Rezoning Transportation Analysis

Petition Number: 2023-023

Date	Description
7-26-23	First Review (IW)

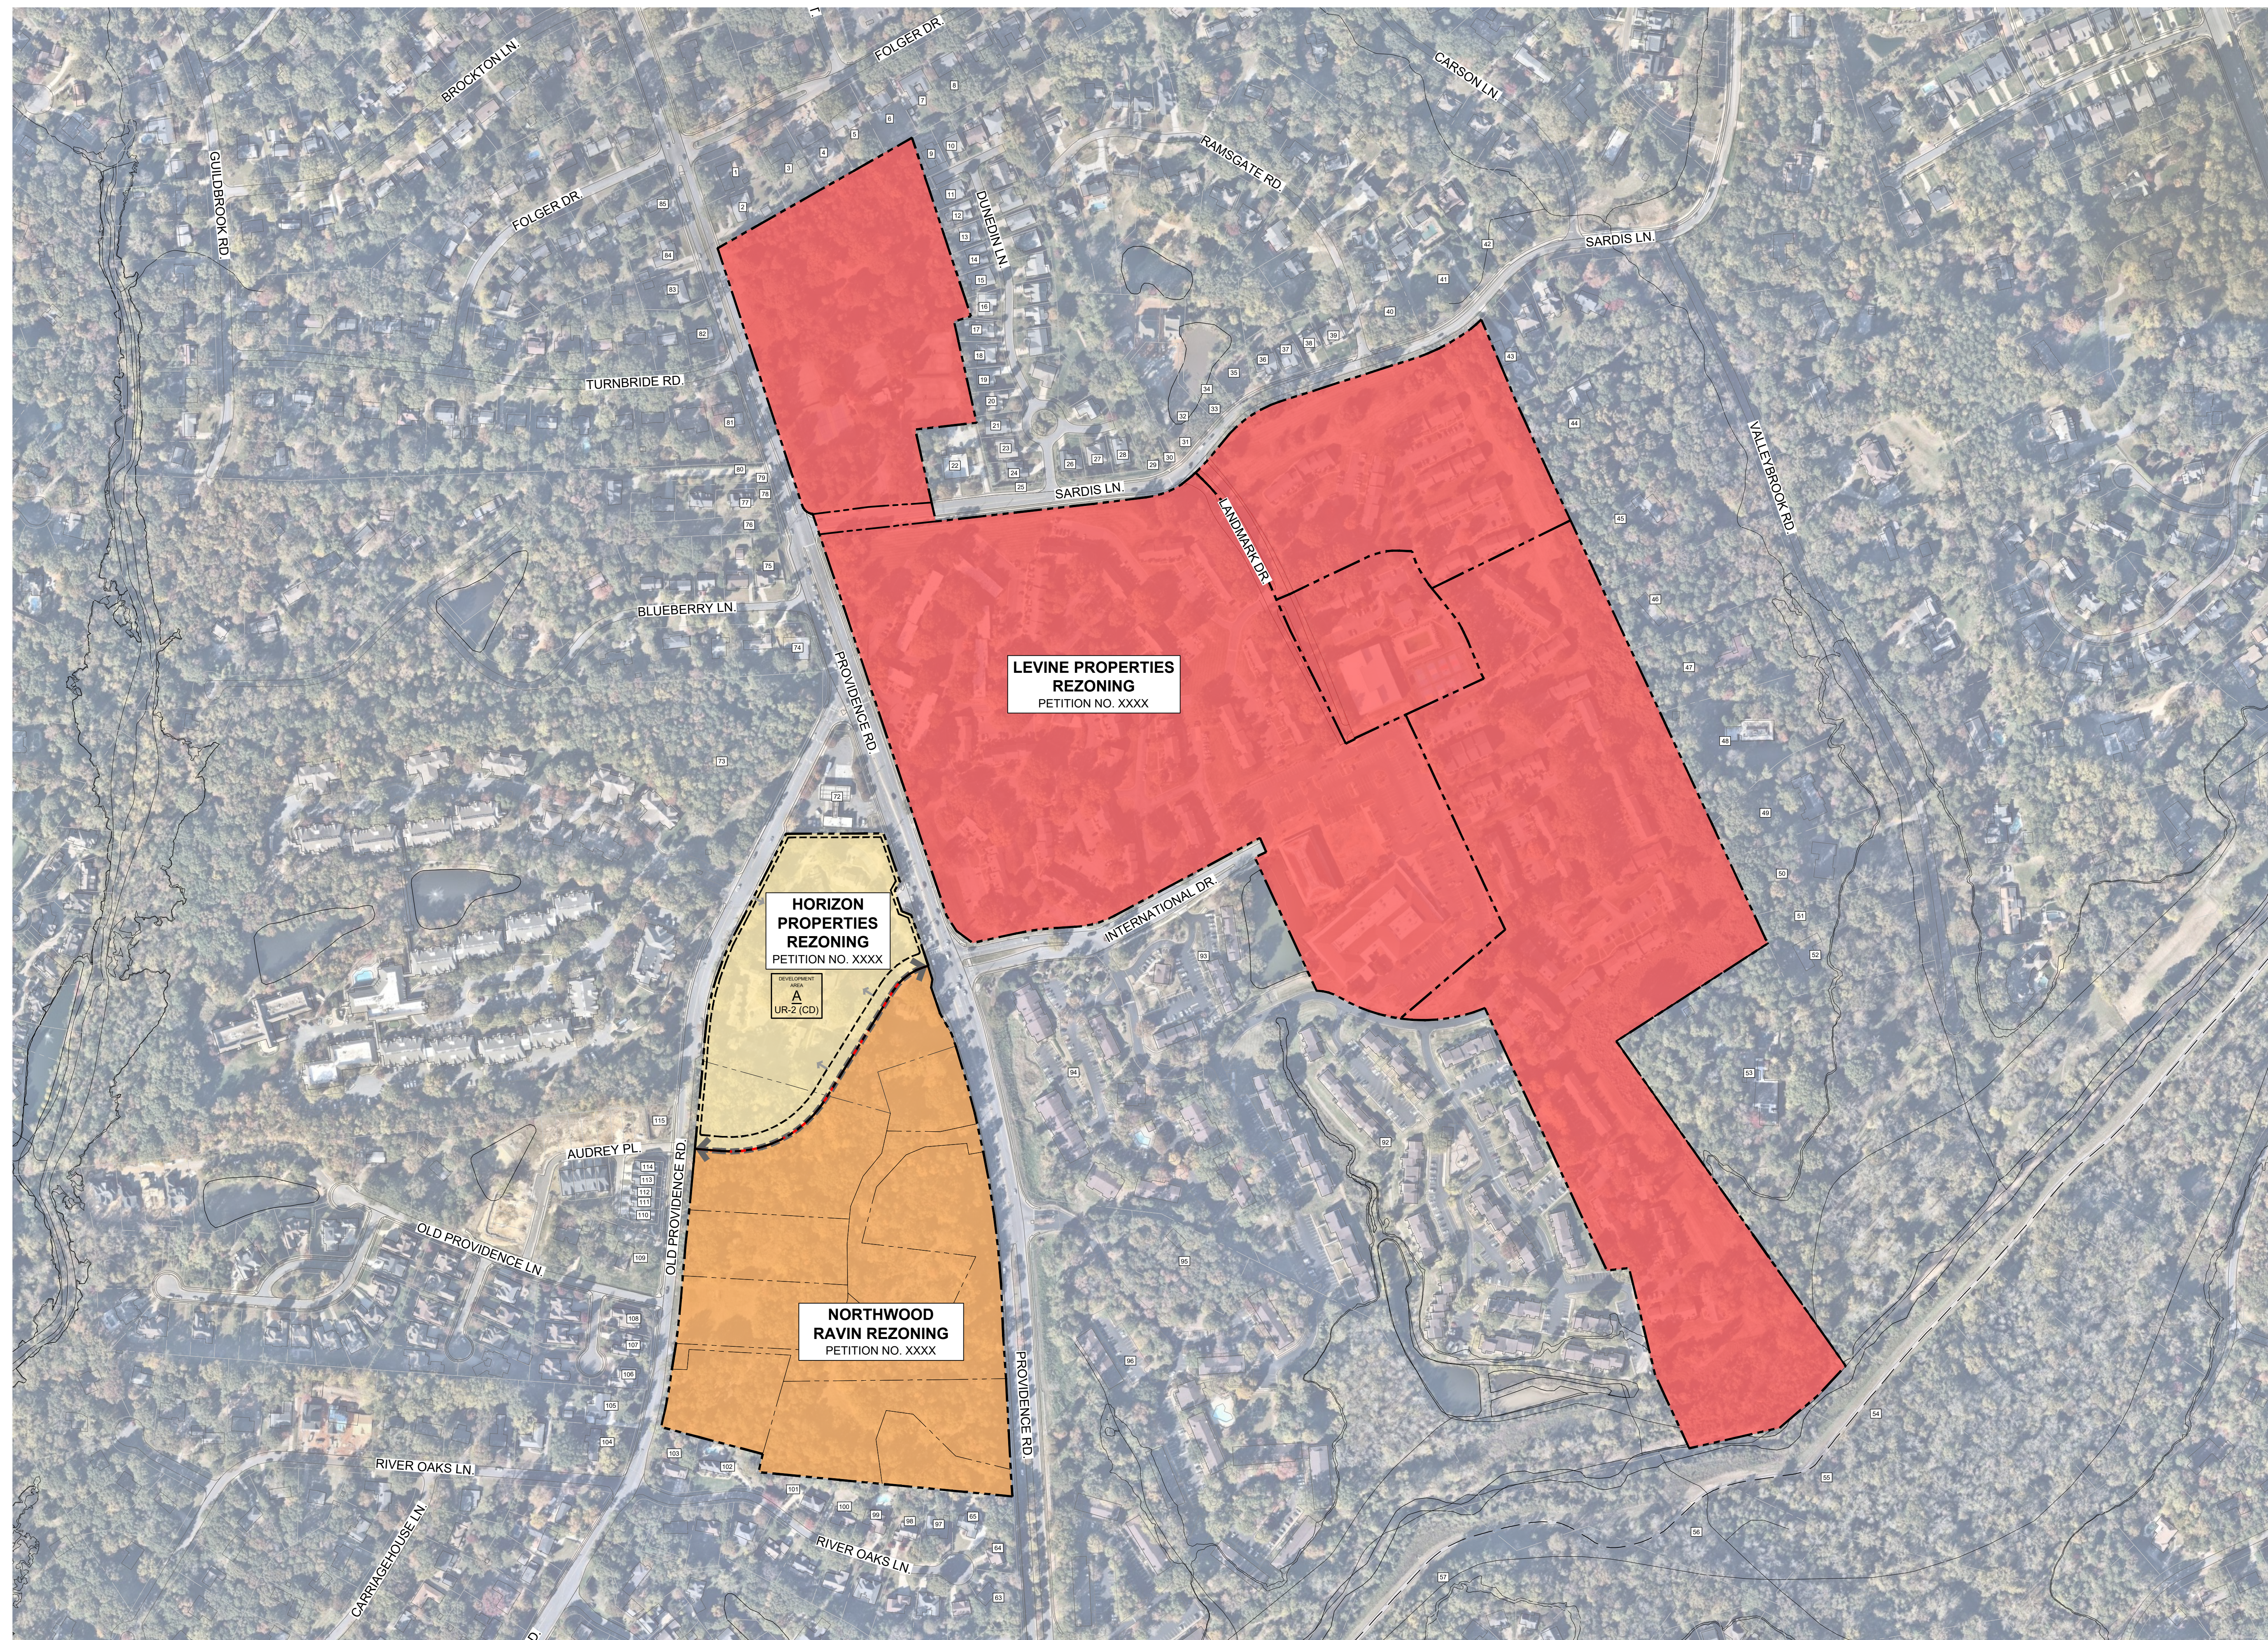
- a. **Providence Road:** Location of back of curb and gutter to be moved to 33 feet from roadway centerline to accommodate the Charlotte Streets Map with a roadway typical section of 4+ Boulevard, shared use path.
 - i. This dimension could change depending on mitigations that come out of the Traffic Study.
- b. **Old Providence Road:** Location of curb and gutter to be moved to 27 feet from roadway centerline to accommodate the Charlotte Streets Map with a roadway typical section of 2+ Avenue Buffered/Separated Bike Lanes.
 - i. This dimension could change depending on mitigations that come out of the Traffic Study.

Label and dimension the curb and gutter from the centerline for each road on the site plan.

4. Revise site plan and conditional note(s) to commit to dedicate 55' of right-of-way from the Providence road centerline. The site plan shall label and dimension the right-of-way from the road centerline.
 - a. This dimension could change depending on mitigations that come out of the Traffic Study.

5. Revise site plan and conditional note(s) to commit to dedicate 43' of right-of-way from the Old Providence road centerline. The site plan shall label and dimension the right-of-way from the road centerline.

- a. This dimension could change depending on mitigations that come out of the Traffic Study
6. Revise site plan and conditional note(s) to commit to construct an 8-foot planting strip, and 12-foot sidewalk on Old Providence Road per the Council-adopted Charlotte Streets map and the Council-adopted Charlotte BIKES Policy. Multi-use paths maintained by the City shall meet ADA/PROWAG requirements. The site plan shall label and dimension both items from the back of curb and gutter or edge of pavement.

7. The proposed dwelling units exceeds 12 per acre. Per Chapter 20 Subdivision ordinance, revise site plan and conditional note(s) to commit to construct an 8-foot planting strip, and 8-foot sidewalk along Old Providence Road. The wider sidewalk also meets the Charlotte WALKS Policy.
